# CITY OF PORTLAND BUILDING PERMIT

Job ID: 2012-11-5409-POOL

has permission to Install an above ground pool; no (new) decking.

# MORTGAGE LOAN INSPECTION

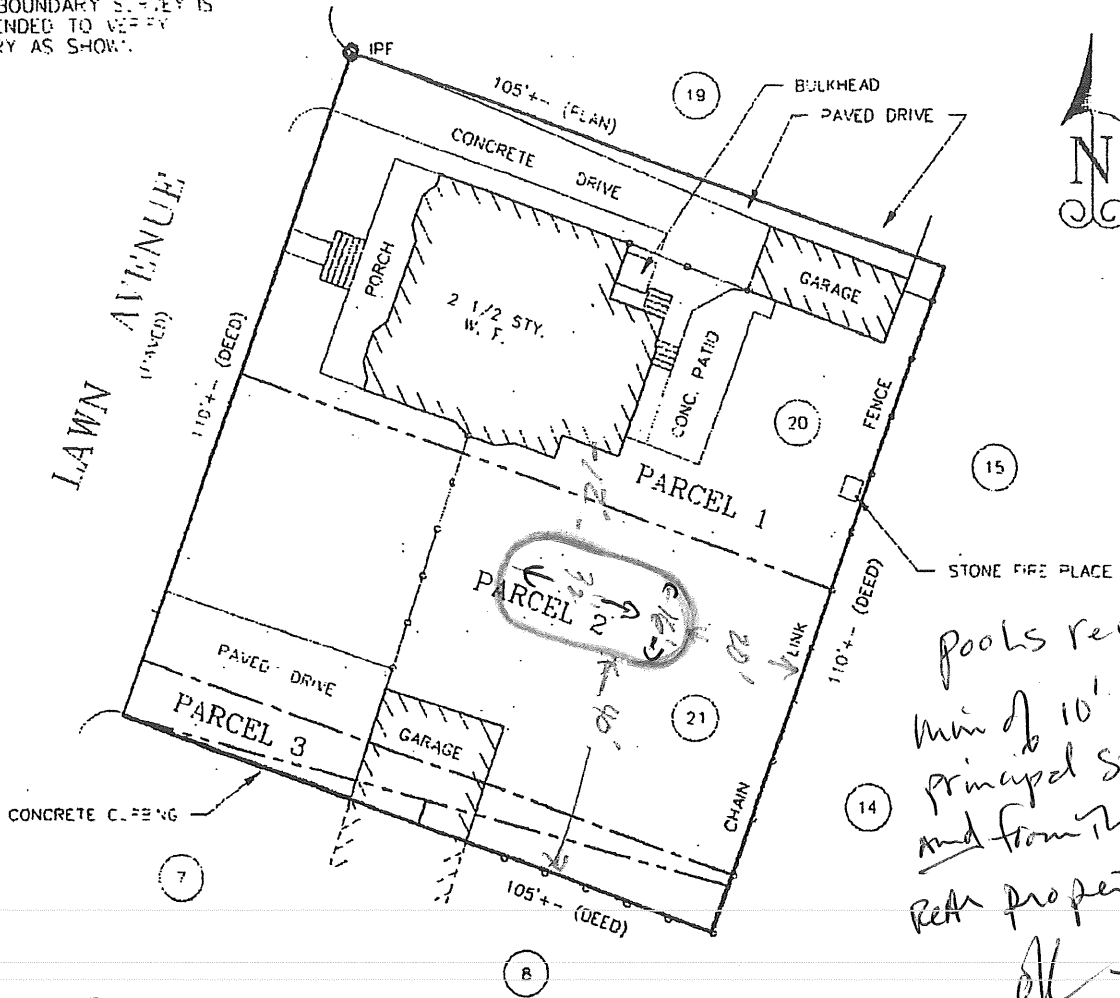
*Handwritten note:*  
Pools require A  
min of 10' from the  
principal structure  
and from the side &  
rear property lines  
OK [Signature]
